Re: MMC Design review

1) Design submission for Planning Board workshop 2/27 - Staff suggest the PB workshop submission include at least a written narrative addressing the design points below which may also include some visual examples of past design iterations. The PB workshop presentation should definitely include visual responses to some of these points as we discussed in the meeting last week.

2) Design Comments - Based on the design meeting last week, staff continue to have the following comments/questions on the current proposal:

TITLE
EAST ELEVATION

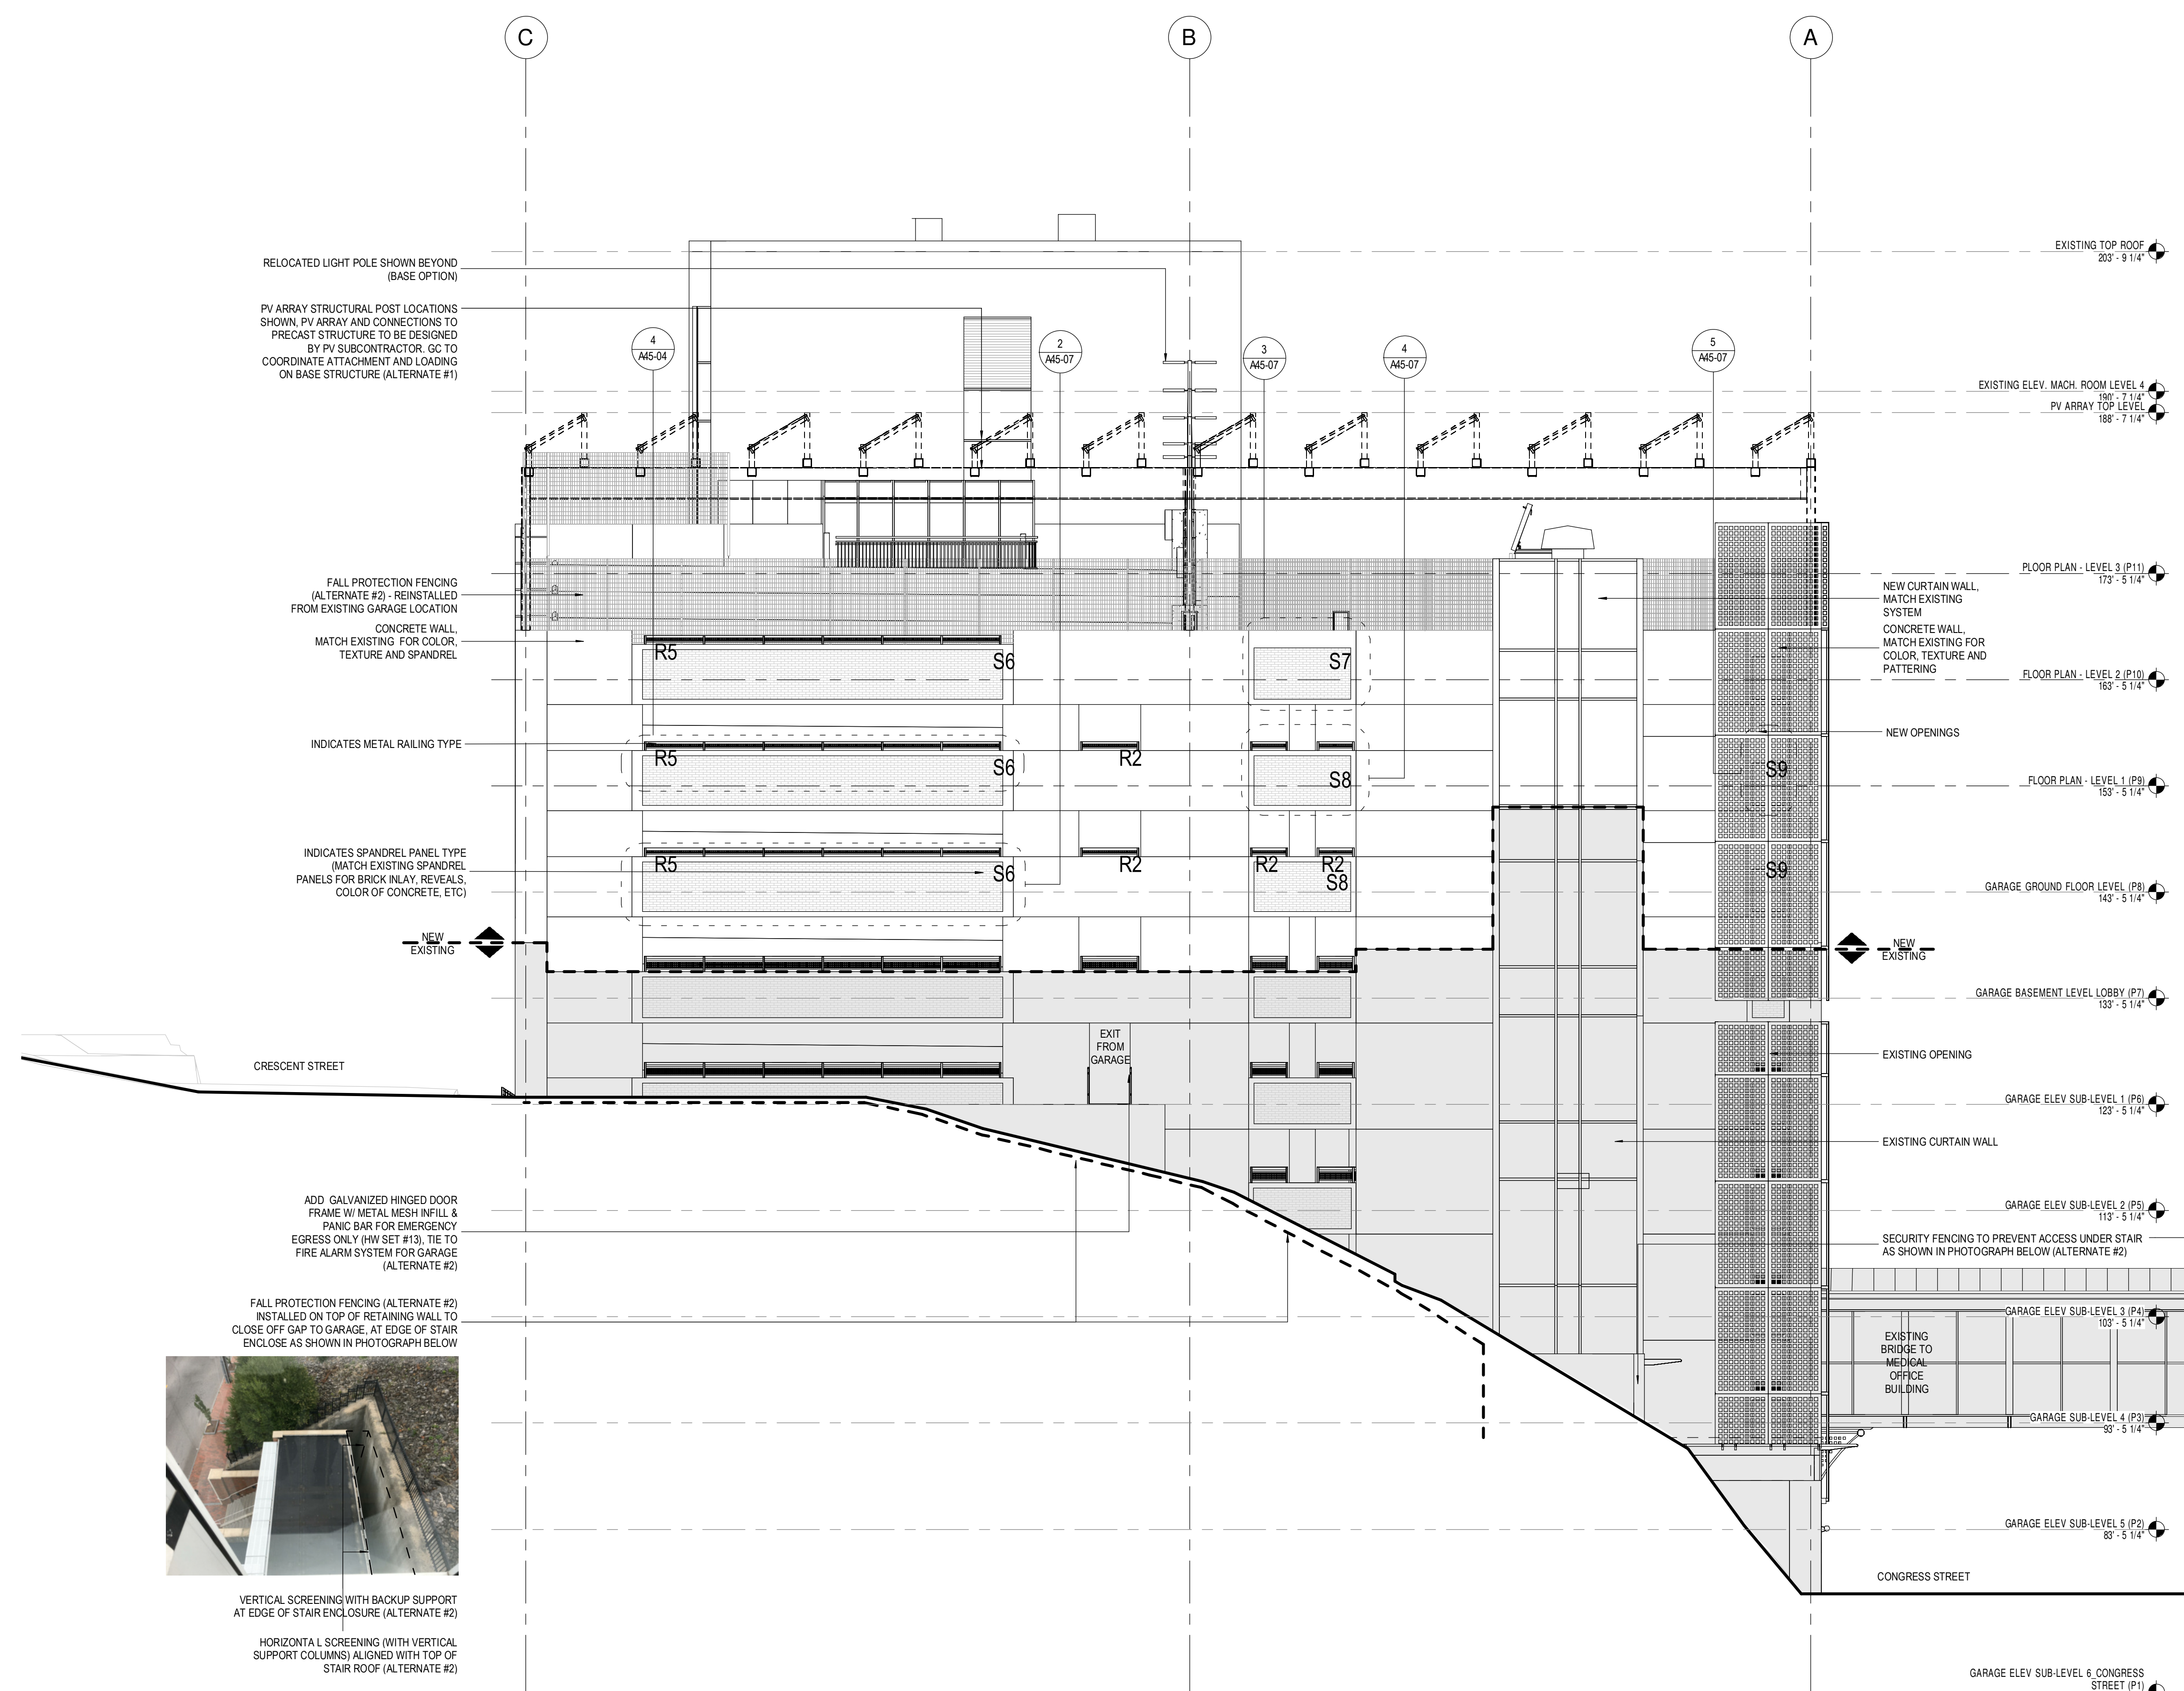
- Mixed feelings about use of white panels - too sterile or stark contrast, not recessive enough?
 1. Provide renderings showing options for material choices, grey or silver were specifically mentioned
 2. Respond to question about re-cladding existing white on building
- Address request for integration:
 1. Integration of existing building elements and new - looks like an addition
 2. Clarify integration of East Tower proposal related to future campus design
 3. Integration into neighborhood (especially at the edges, entrances, blank walls, retail)
- Long-term plan for Congress Street retail facade improvements
- How will streetscape at South Entrance change when new entrance is added on Congress Street?
- Screening of mechanicals on garage
- Concerns with parking garage design - rooftop fence quality, facade improvements

- **East Tower:** Staff, aligned with PB comment, continue to have some concern about the facade integration of the new and existing - especially in overall facade composition, proportion, and articulation. The existing building has a high level of articulation while the proposed new is much more minimal. Please clarify where new metal panel is proposed and where existing to remain and the strategy around getting those to match or blend. Staff suggest you consider articulation strategies in the new section that address these integration concerns whether that is a horizontal band, dimensional elements, color or other strategies.
- **Garage:** There are two opportunities to update or improve the design character of the garage - the fall protection fence, especially on the top level, and the metal screens.
